2024 / 3089 - BCA Report (short) DA Submission

Macarthur Gardens North R3
Goldsmith Ave. Campbelltown

Preliminary BCA and Certification Assessment

Drawing Name
Basement 1

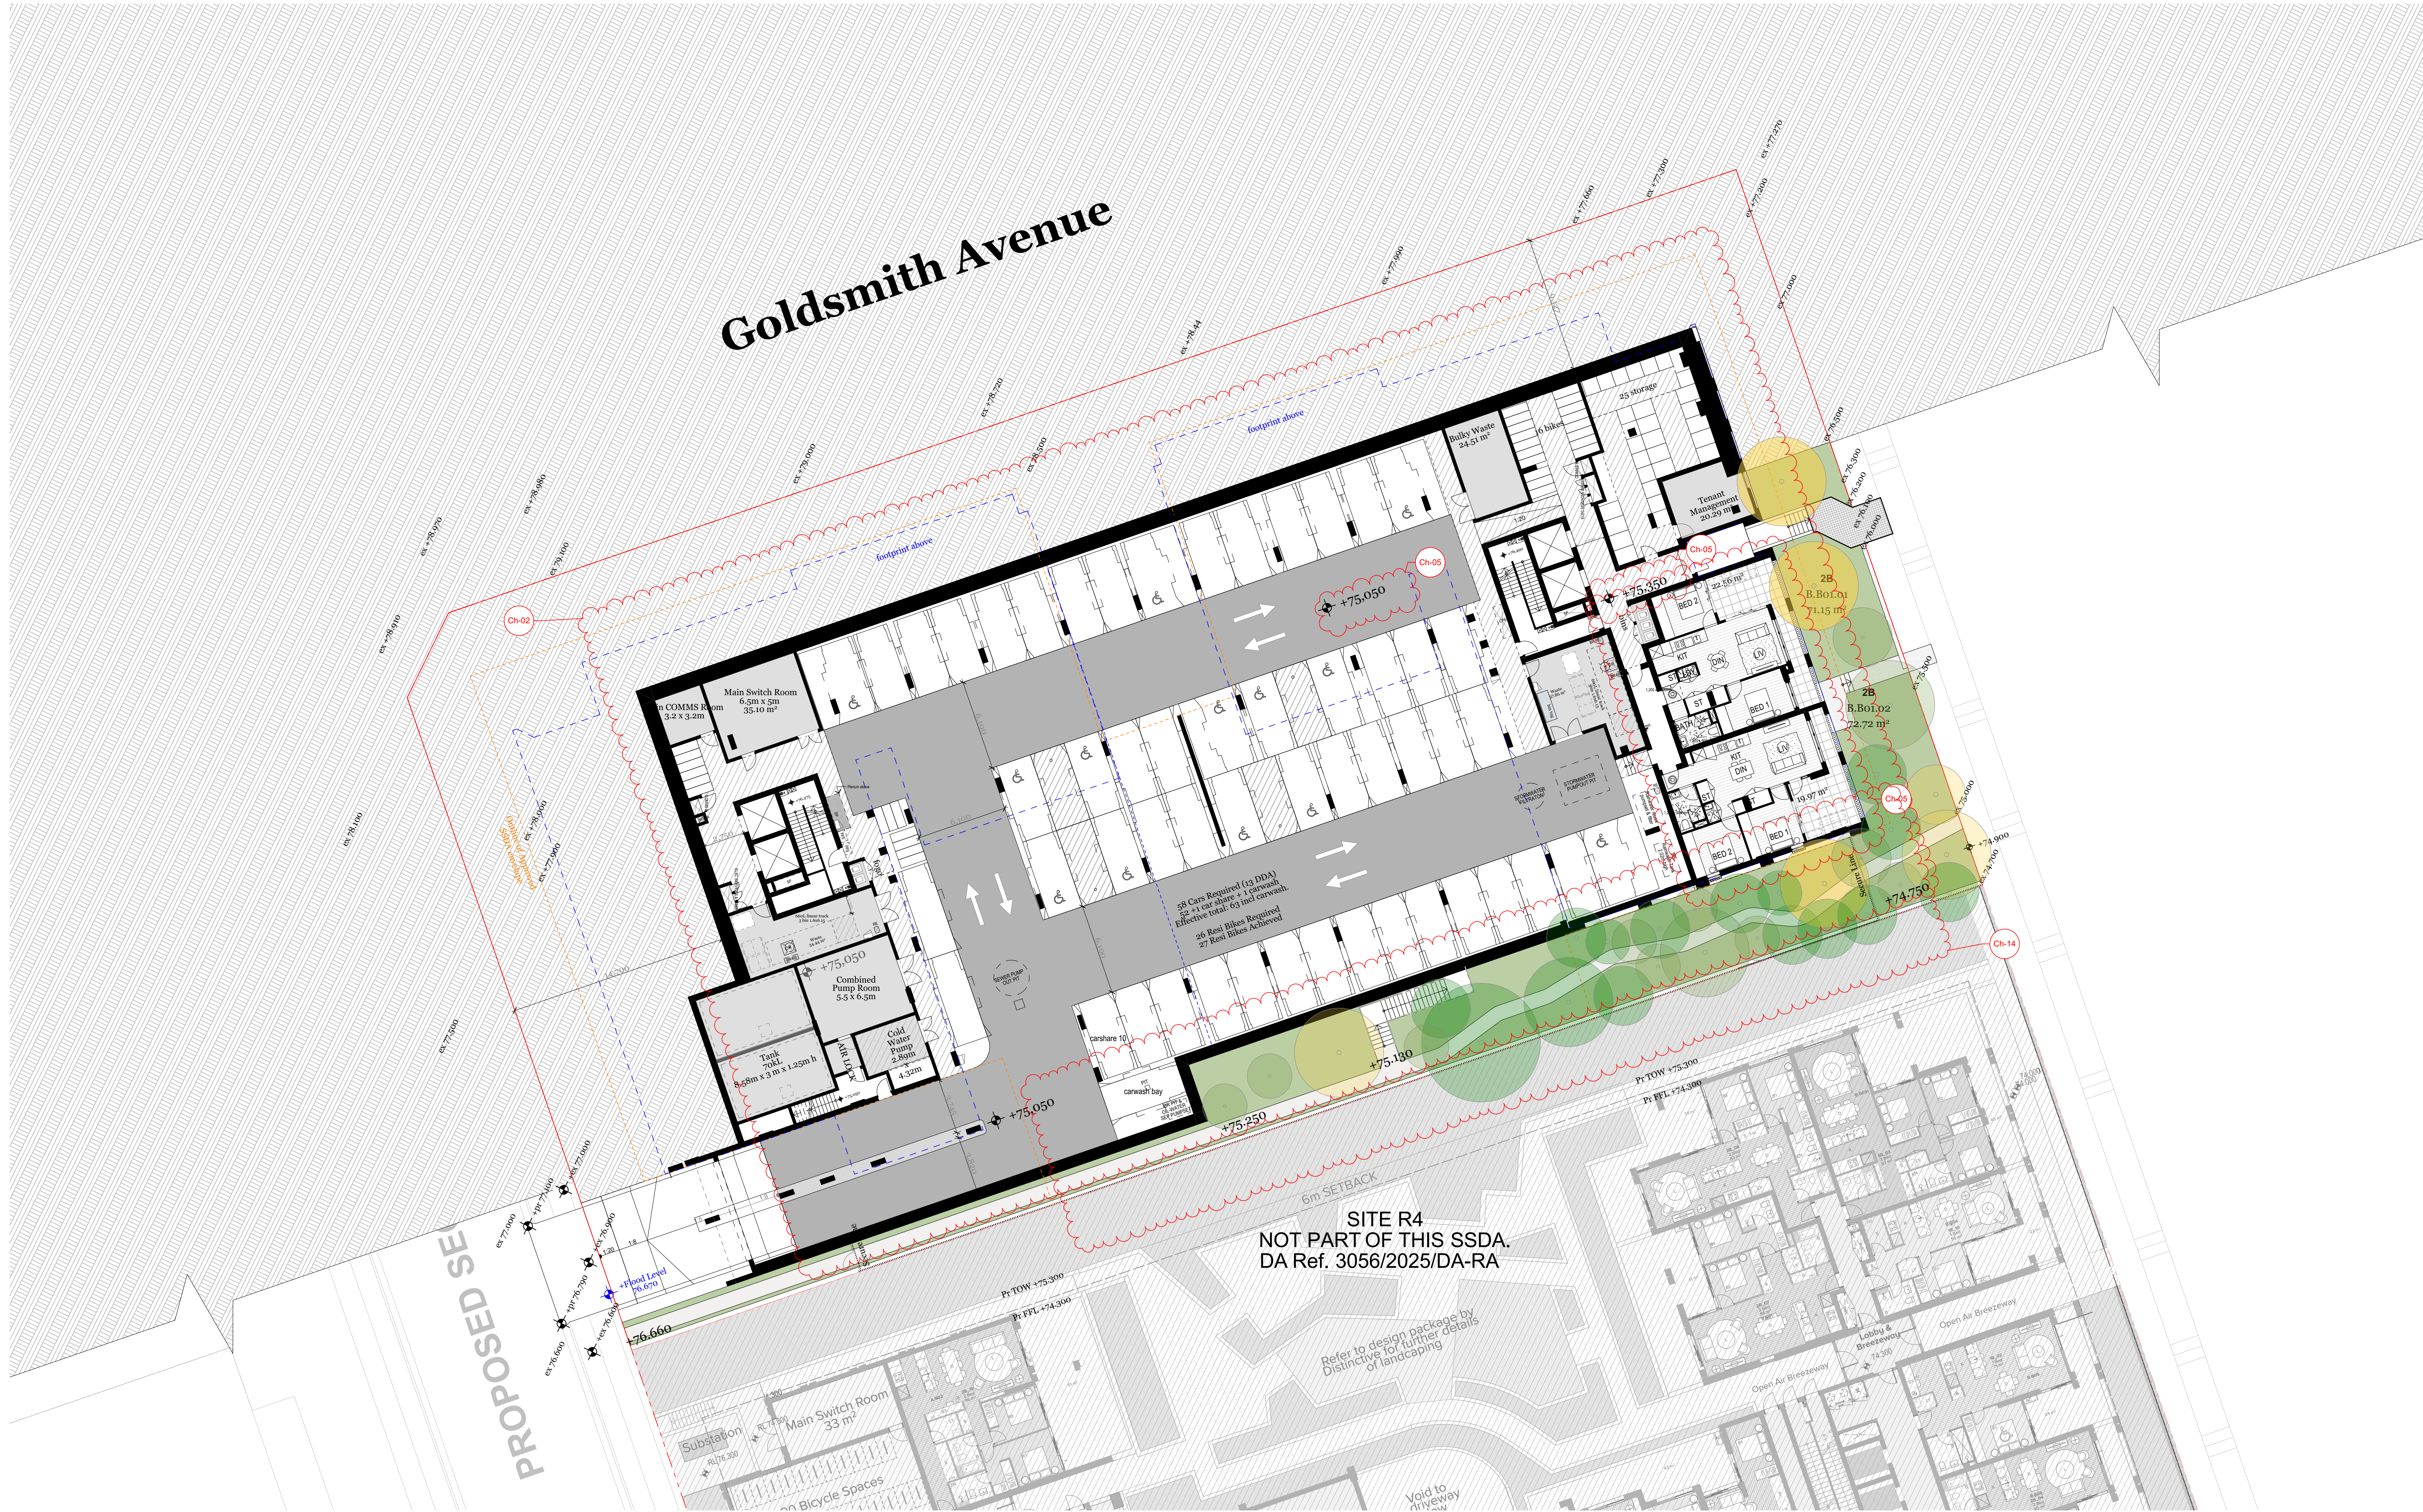
The top and bottom of all shafts must be enclosed by construction having a FRL. The garbage chute is not proposed to be isolated at the base / garbage room. Details of the roof access hatch should be assessed at CC stage, the stair / ladder may affect the corridor path of travel.

- The number of accessible car parking spaces will be addressed by a Performance Solution.
- Access to the B1 residential units will be addressed by a Performance Solution.

Item	Non-Compliance	DTS Clause	Performance Requirement	Description
1.	Bottom of garbage chute is not enclosed at basement 1 level	C2D2, S5C8	C1P2 C1P8	The top and bottom of all shafts must be enclosed by construction having a FRL. The garbage chute is not.
